**WELWYN HATFIELD BOROUGH COUNCIL
EXECUTIVE DIRECTOR - PLANNING, PUBLIC PROTECTION AND GOVERNANCE**

DELEGATED APPLICATION

Application No: 6/2020/1990/PN11
Location: Everest House Sopers Road Cuffley Potters Bar EN6 4SG
Proposal: Prior notification for the change of use from office (B1A use class) to residential (C3 use class) to create no. 32 residential units.
Officer: Mr Antoine Commenville

Recommendation: Prior Approval Required and Refused

Drawing title
Proposed Ground
and Lower Ground floor Plan

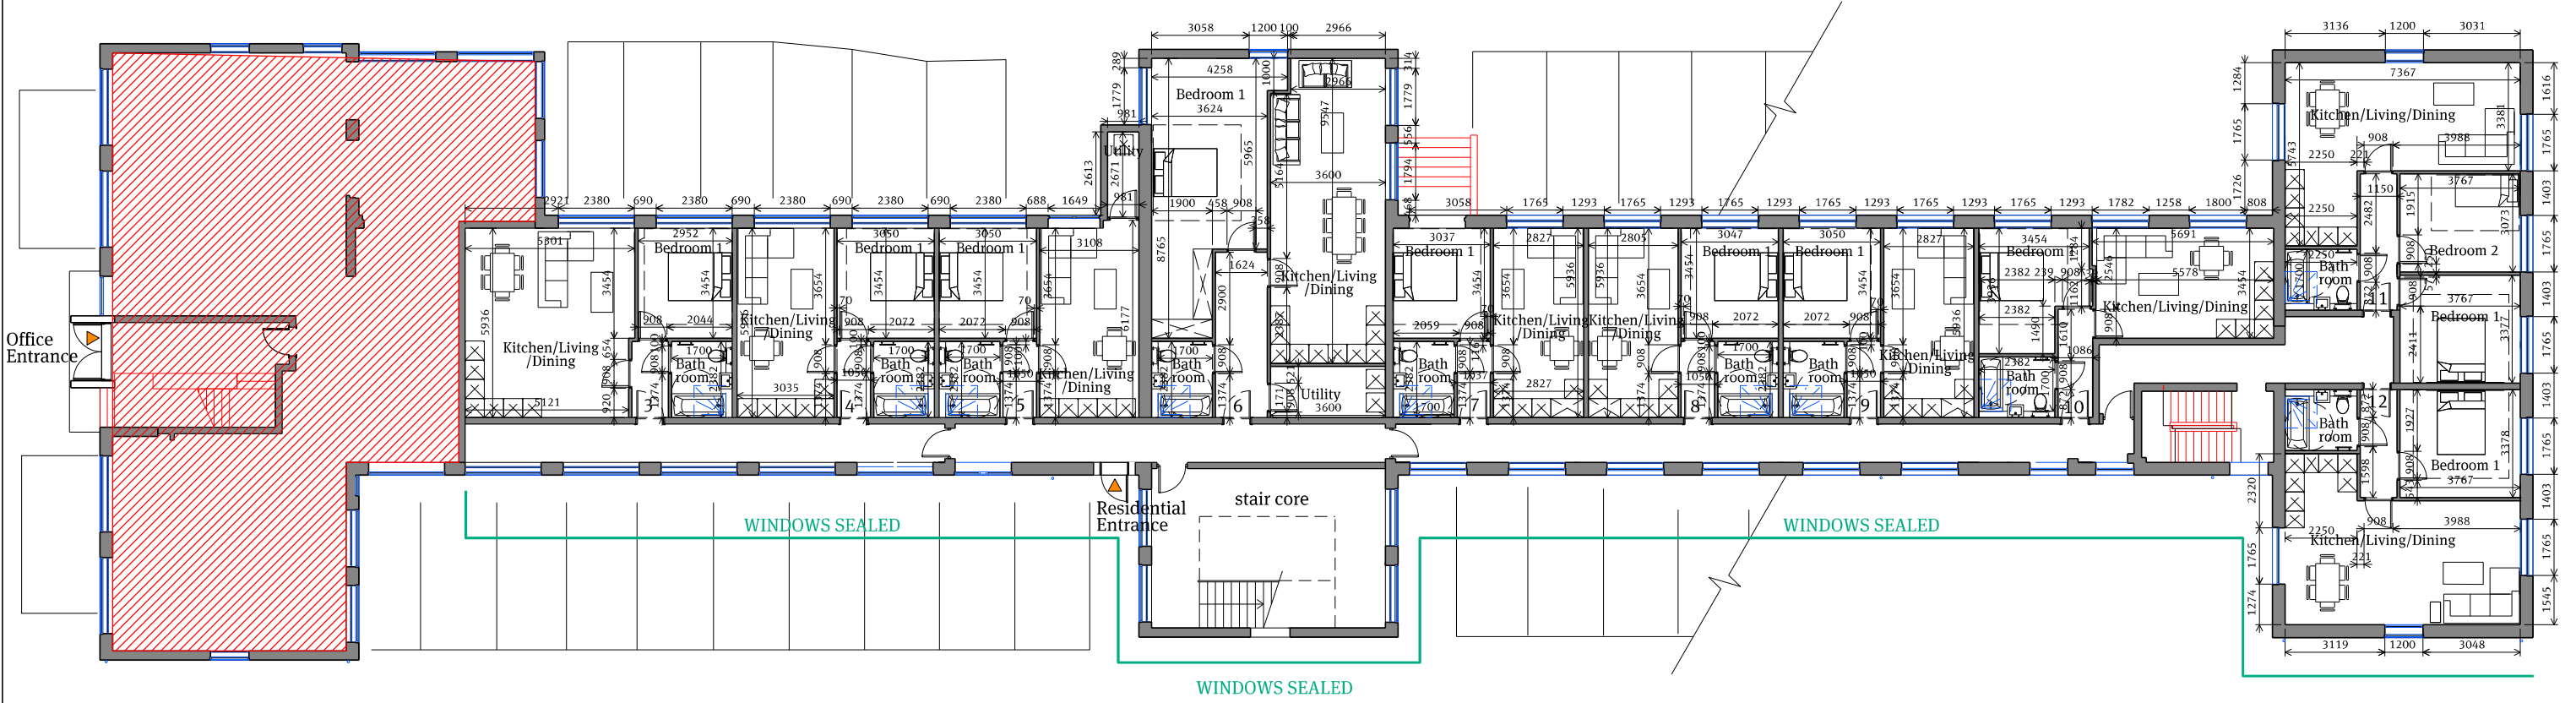
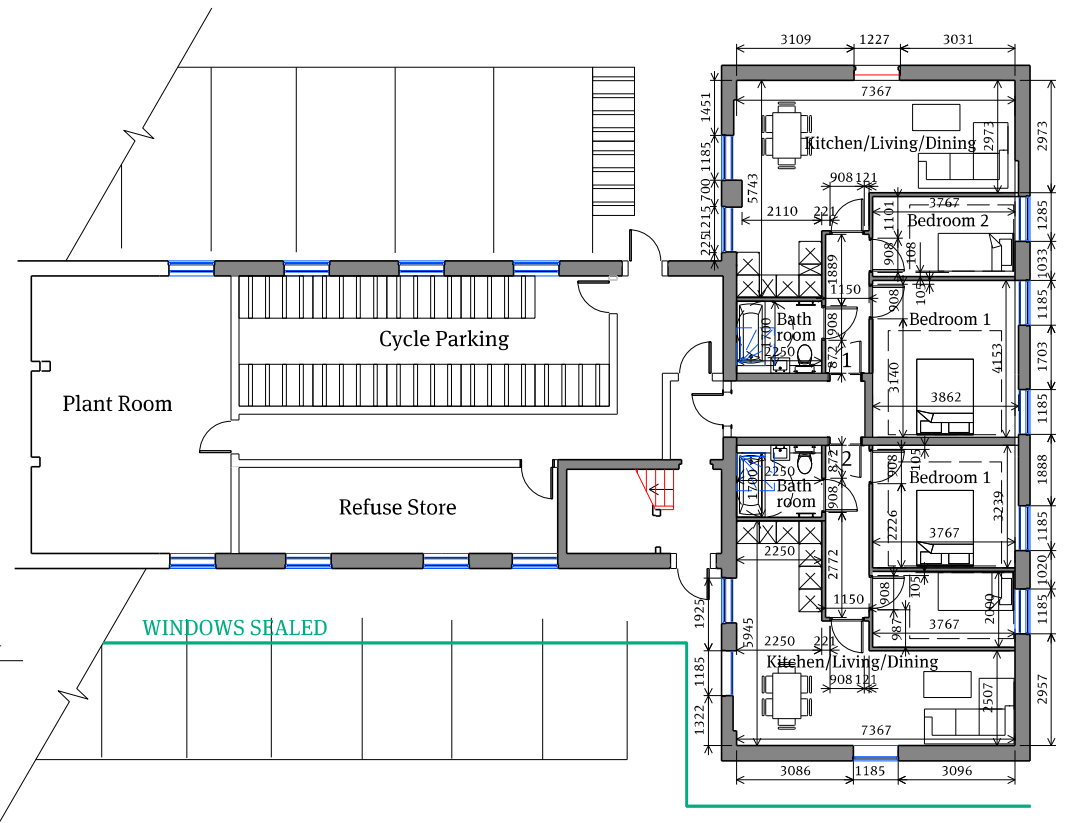
The subject site is located to the eastern side of Sopers Road that is designated as a local distributor road and is subject to a 30mph speed limit along this section of road. Since no detailed site layout plans were submitted to show the access to/from Sopers Road and internal arrangements it is unclear what access provisions would be for the new use and how access will be shared between the residential and the office use remaining on site.

It is acknowledged that the proposed change of use should result in a reduced trip generation for the site overall. However, although the number of vehicle movements during peak times is likely to decrease in comparison to the current use, the aims of the LTP4 and NPPF are to promote walking and cycling and to this end, the Highway Authority requests that more information is provided on the cycle parking and how would a lower ground floor be accessed from the units themselves and from the public highway.

In line with the LTN 1/20 cycle parking should also offer an option for storage of non-standard bicycles like tricycles, cargo bikes, handcycles (normally 5% of the total cycle parking provision) and offer the highest level of security to encourage cycling in line with the NPPF and the LTP4. No cycle parking is proposed for visitors but should be made available in a secure and overlooked location.

The site will require access by domestic waste collection vehicles, yet there is no information provided as part of this submission to explain how refuse and servicing will be undertaken. It should be noted that there are distance limits for refuse vehicle operatives to walk from the truck to the collection point and trucks should not reverse more than 12m. Likewise, the applicant should demonstrate that refuse areas are within acceptable walking

In terms of on-site parking, the proposed development would include the provision of 43 car parking spaces (according to the Cover Letter). WHDC's parking standards are set out within the Council's Supplementary Planning Guidance (SPG) and zonal restraint-based approach is applied. The site falls within Zone 4. Although the provision appears to comply with the adopted standards, parking spaces have not been shown on the plans and again it is unclear how these will be accessed or shared with the office use nearby.
